## **Phase 2 – Catalyst, Bicester** **Technical Note – LLFA / CDC Drainage Response**

This technical note has been produced as an addendum to Application No: 22/03677/DISC relating to discharge of Condition 40 (SW Drainage). This condition has been partially discharged for Phase 1 which is now complete. Phase 2 (Units 5-9) is the next and final phase of development for this application. Please find below Bailey Johnson Hayes responses to consultee comments received to date.

Scale: 1:500 @A1 Drawing Number: S1358-DD02 C
Date: 01.07.19
Drawn: JNG

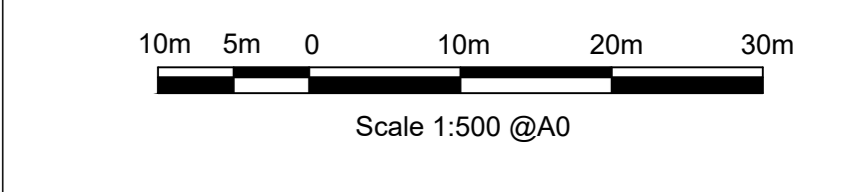
1. Provide pipe numbering on the drainage plan which should read in line with the calculations produced.

Drawings No. S1358-PH2-04B, 06B, 08B and 10B have been updated to provide MircoDrainage calculation pipe numbers and lengths as requested. Please note all pipe number can be found on drawing no. S1358-DD02 Rev C which is appended to the Catalyst Bicester SW Drainage calculations package revision 3.

S1358-PH1-23B

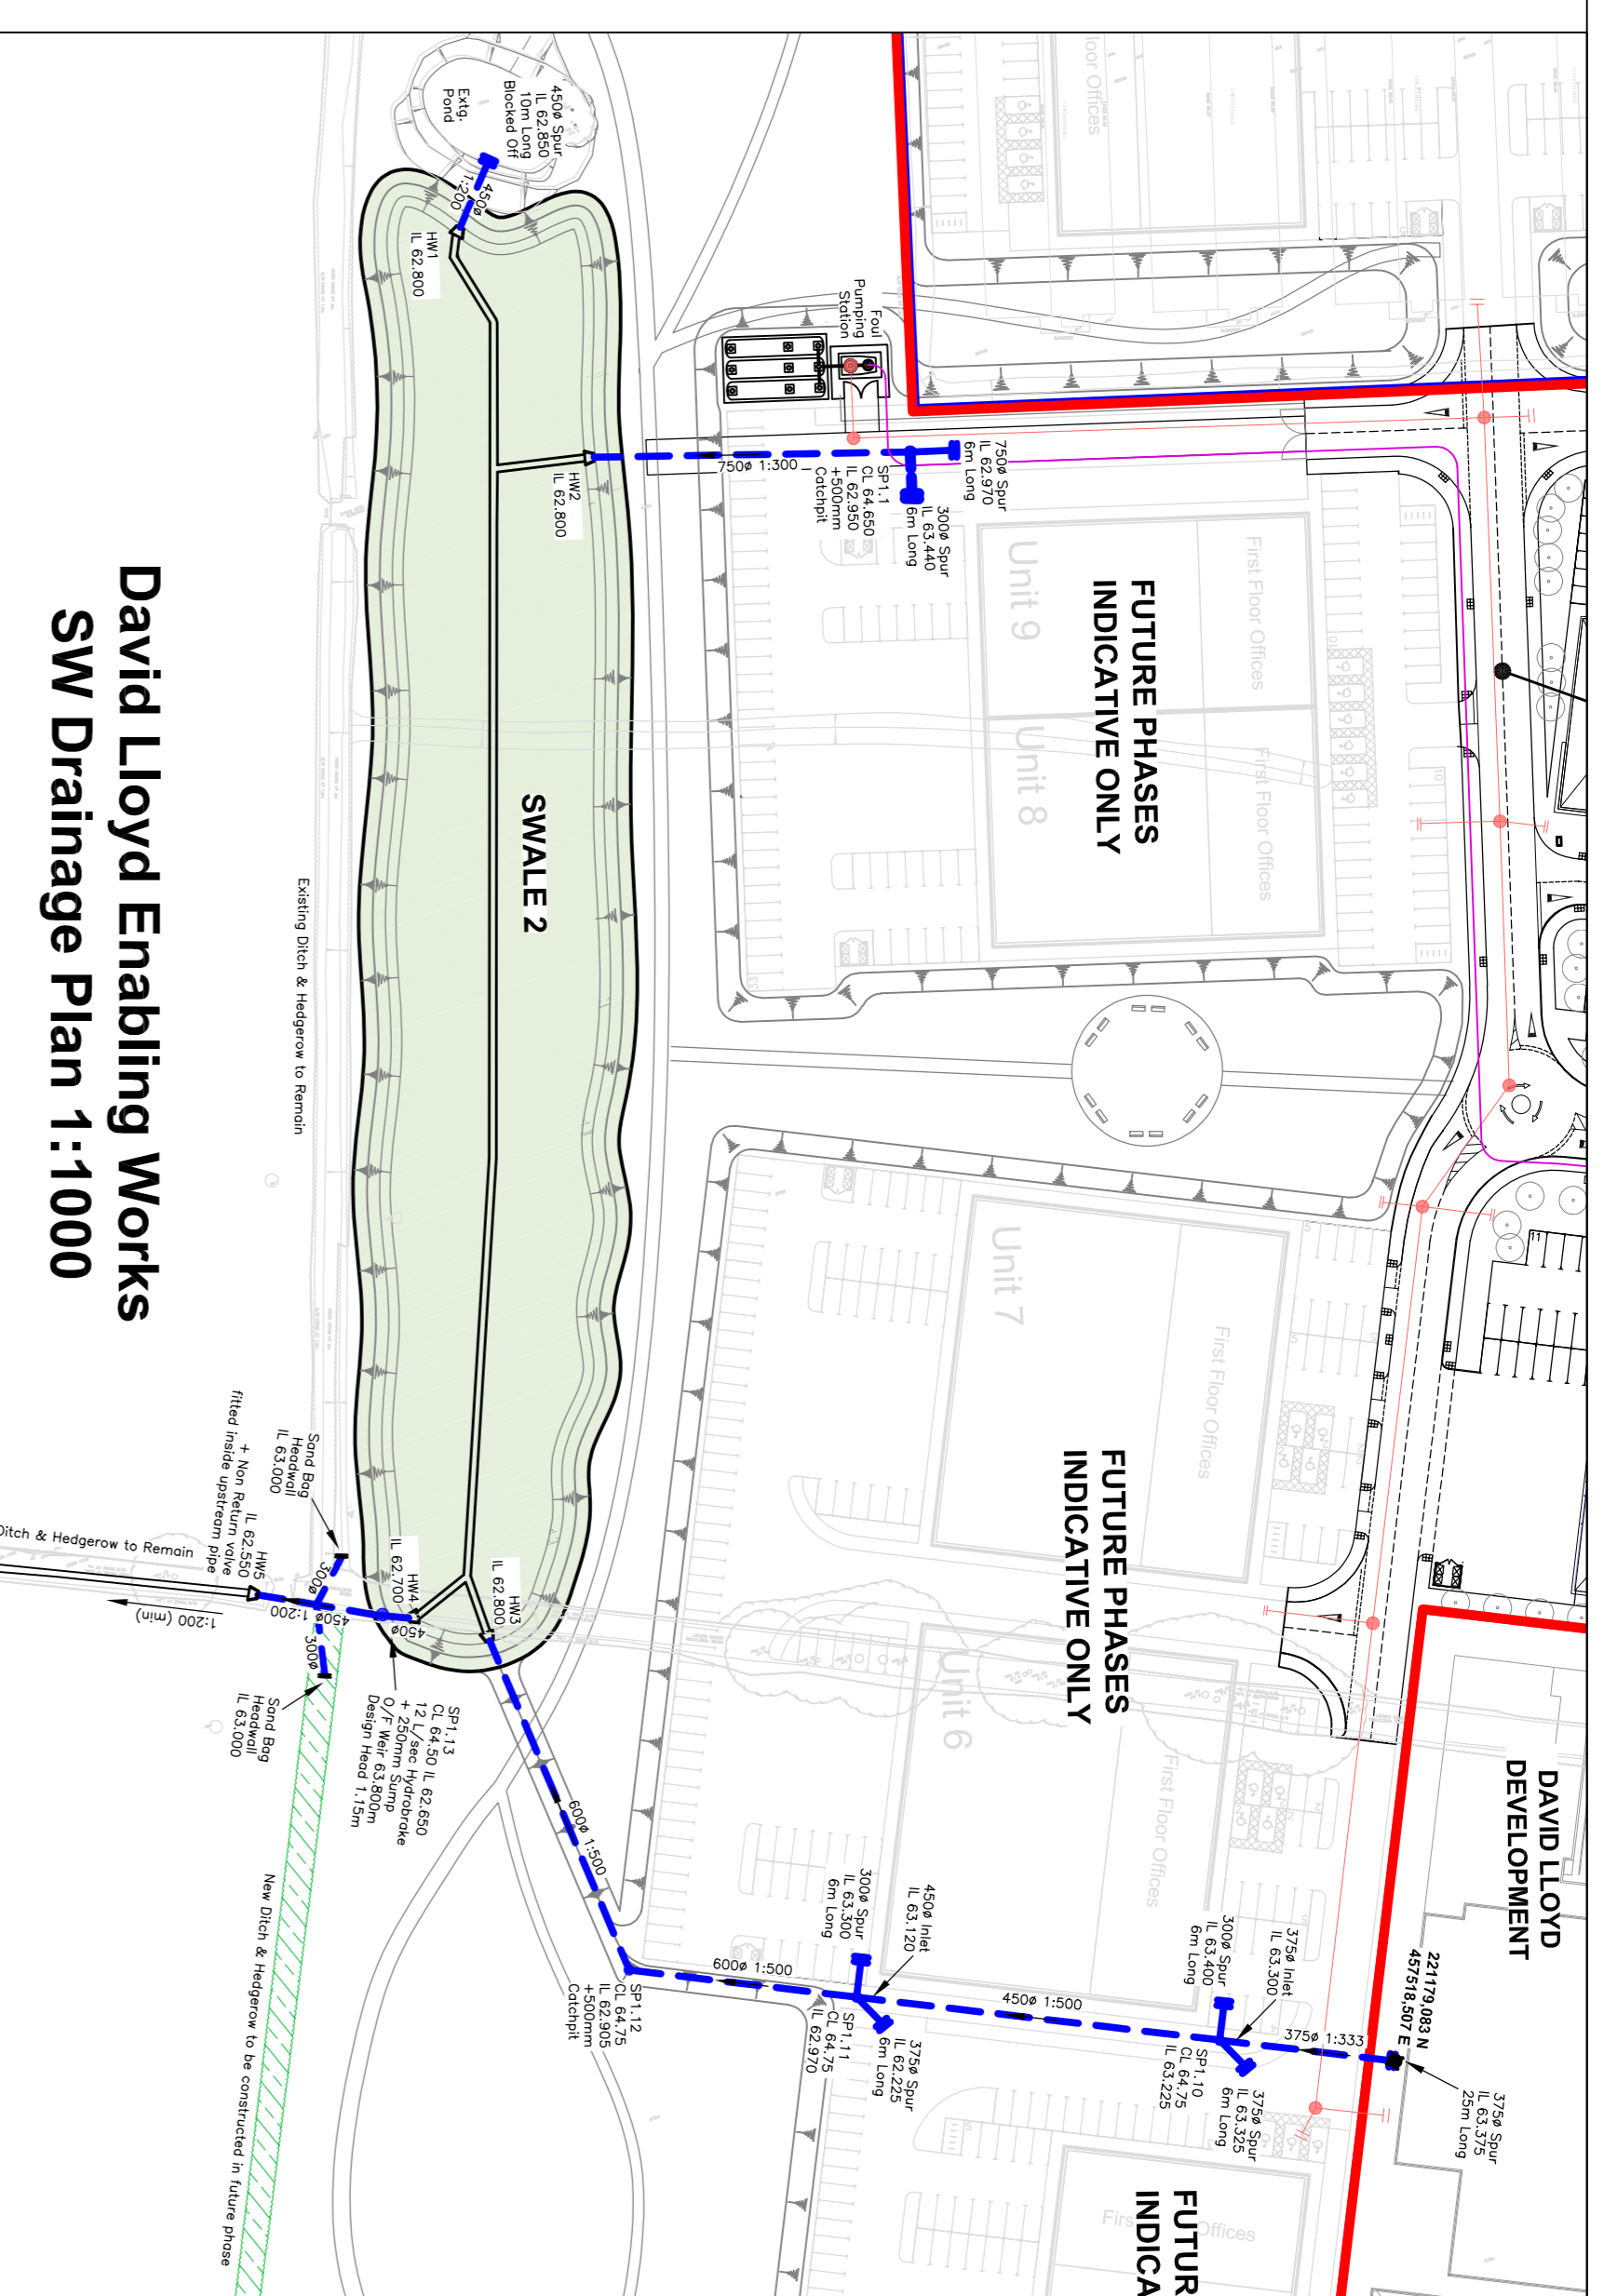
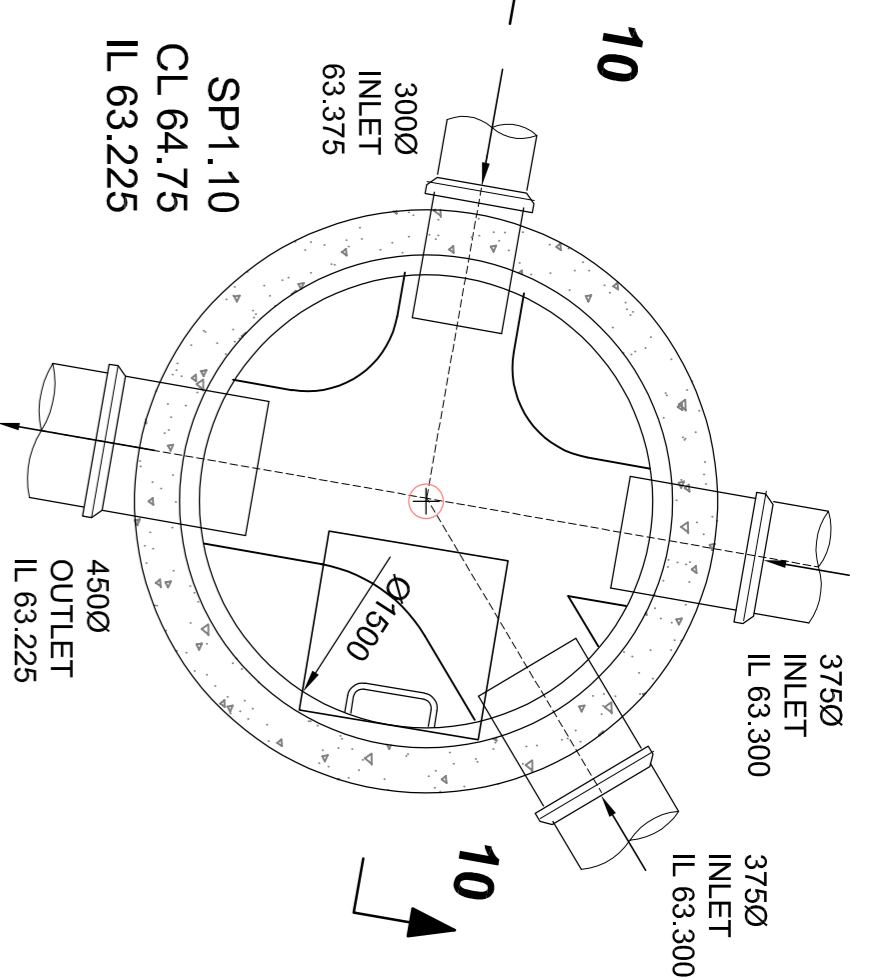
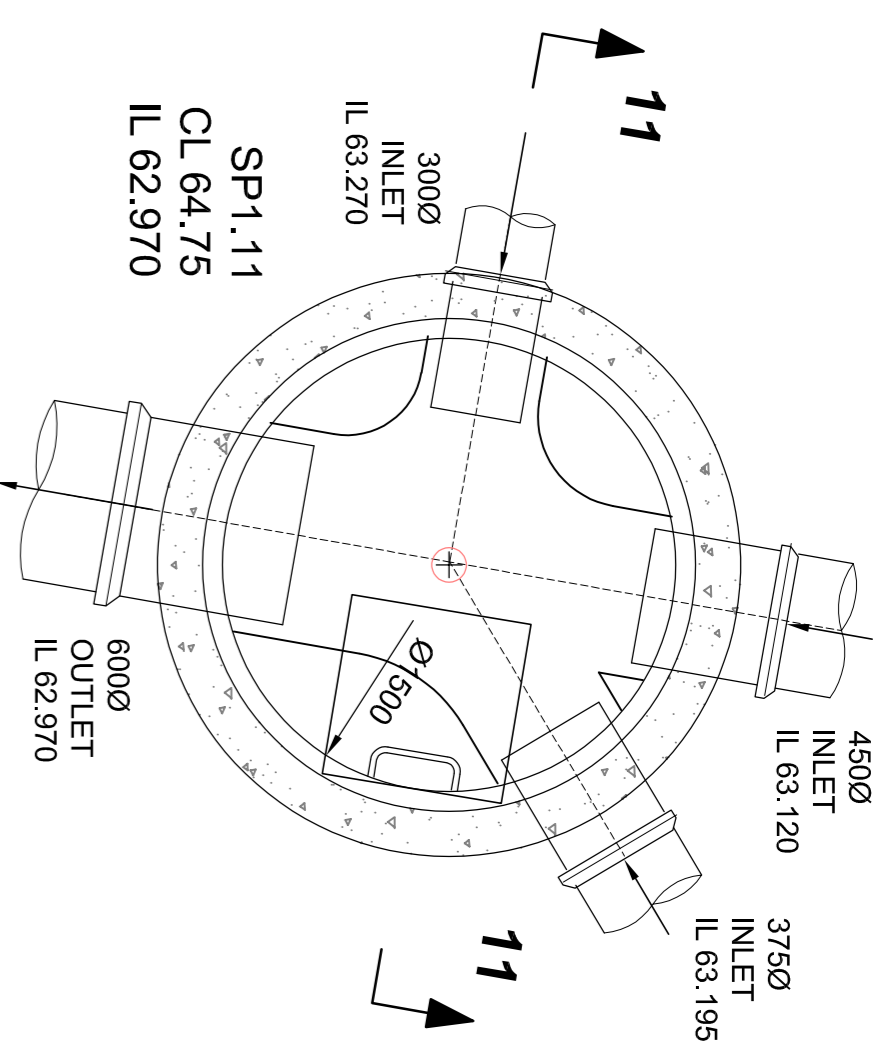
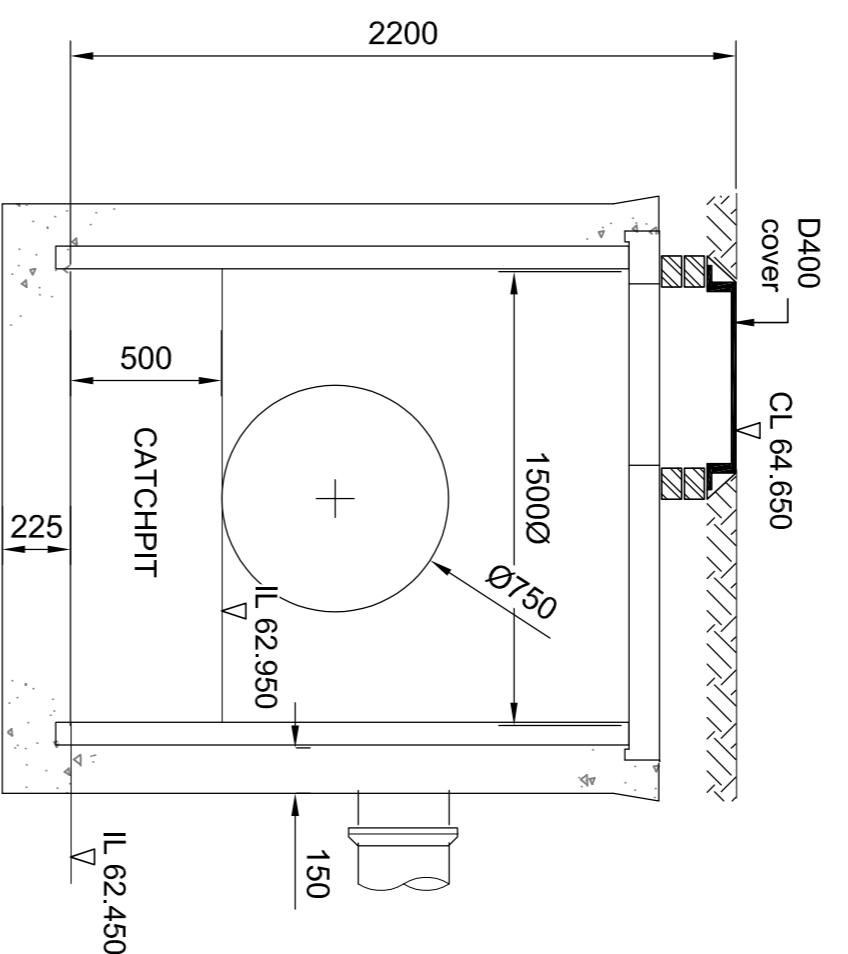
2. Provide SuDS construction details drawings.

New Drawings No. S1358-PH2-17A, 18, 19, 20, 21, 22 & S1358-PH1-23 are now submitted to provide full details of the Attenuation Basin 2, Petrol Interceptors 3-5, Permeable Paving, Hydro-brake outlet manhole, headwalls, culverts and ditches.
